Subject: Rezoning Petition Review

Date of Review: April 28, 2022 (*Revised June 29, 2022*)

Rezoning Petition #: 21-259

Location of Property: Approximately 3.57 acres bound by the north side of M Tryon St, east side of W 26th St, west side of W 27th St and south side of N Church St.

**RZ.01**

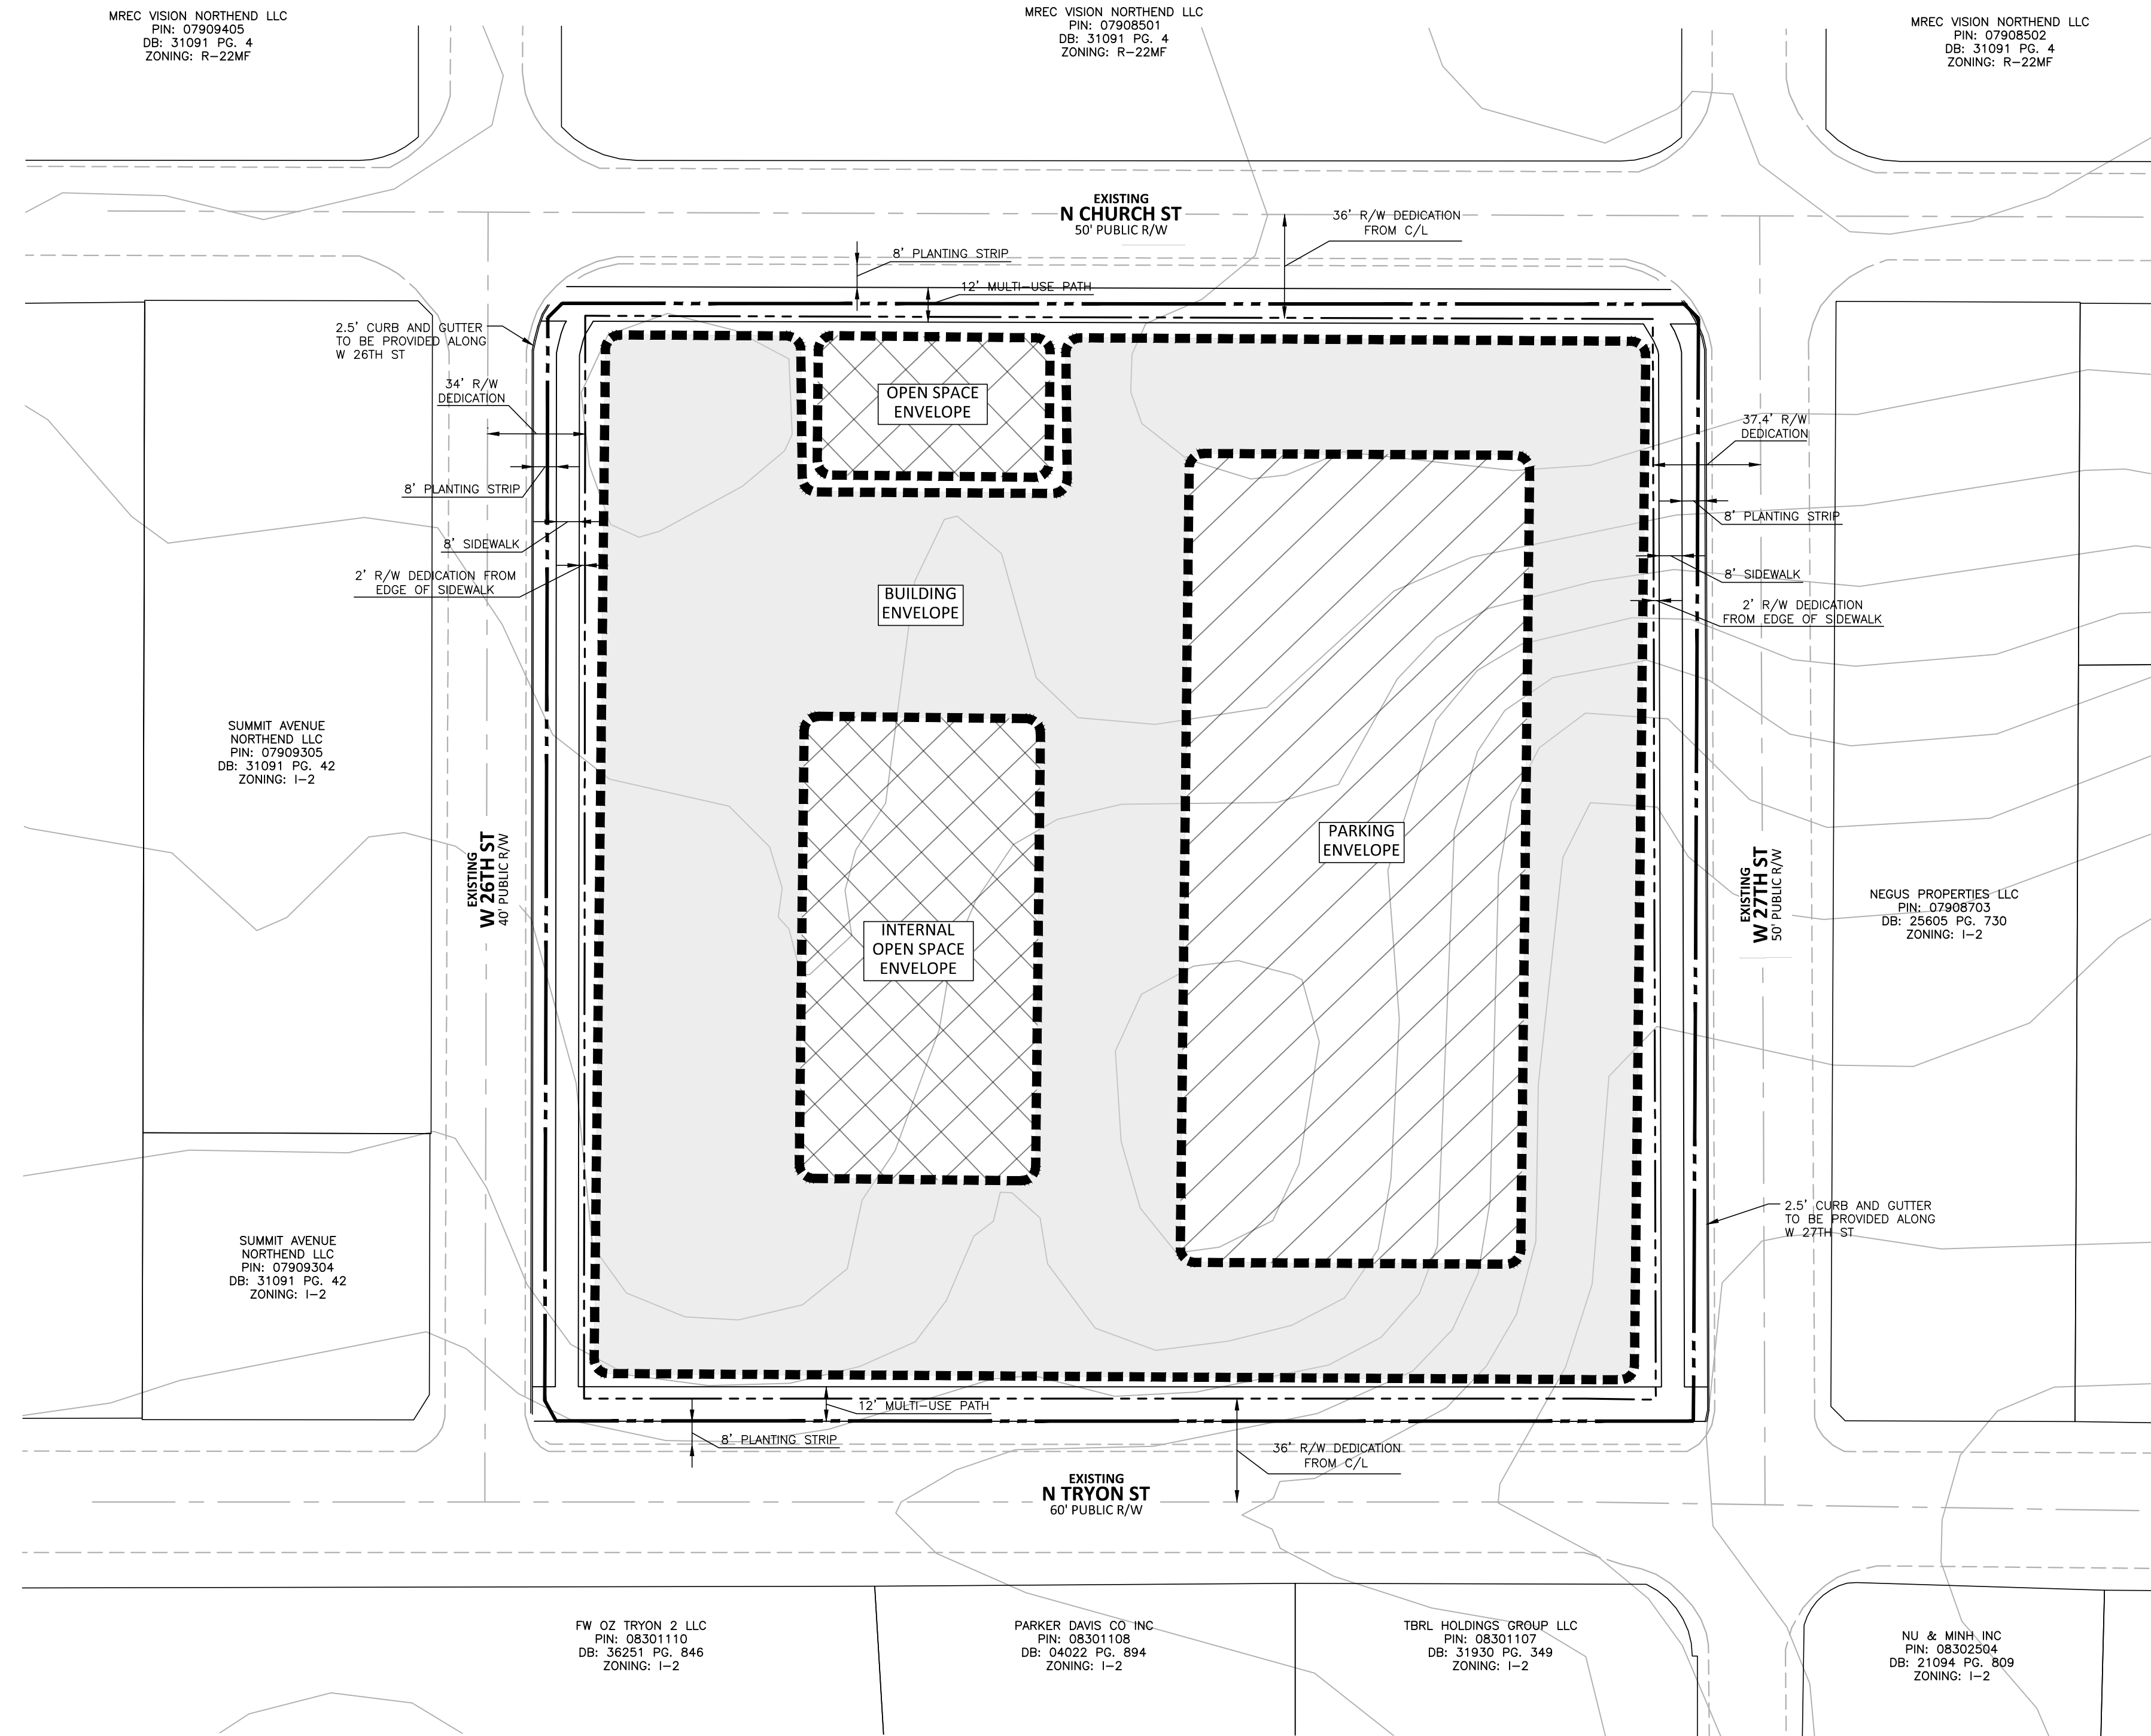
This property drains to Upper Little Sugar Creek, which is an impaired/degraded stream, and may contribute to downstream flooding. This project has the opportunity to mitigate future impacts to this stream, therefore, Storm Water recommends placing the following notes on the plan:

For defined watersheds greater than 24% built-upon area (BUA), construct water quality stormwater control measures (SCMs) designed for the runoff generated from the first 1-inch of rainfall for all new and redeveloped BUA associated with the project. SCMs must be designed and constructed in accordance with the Charlotte-Mecklenburg BMP Design Manual.

For defined watersheds greater than 24% built-upon area, control the entire volume for the 1-year, 24-hour storm for all new and redeveloped BUA associated with the project. Runoff volume drawdown time shall be in accordance with the Charlotte-Mecklenburg BMP Design Manual.

For commercial projects with greater than 24% BUA, control the peak to not exceed the predevelopment runoff rates for the 10-yr, 6-hr storm and perform a downstream flood analysis to determine whether additional peak control is needed and if so, for what level of storm frequency, or if a downstream analysis is not performed, control the peak for the 10-yr and 25-yr, 6-hour storms.

For residential projects with greater than 24% BUA, control the peak to not exceed the predevelopment runoff rates for the 10-year and 25-year, 6-hour storms or perform a downstream analysis to determine whether peak control is needed, and if so, for what level of storm frequency.
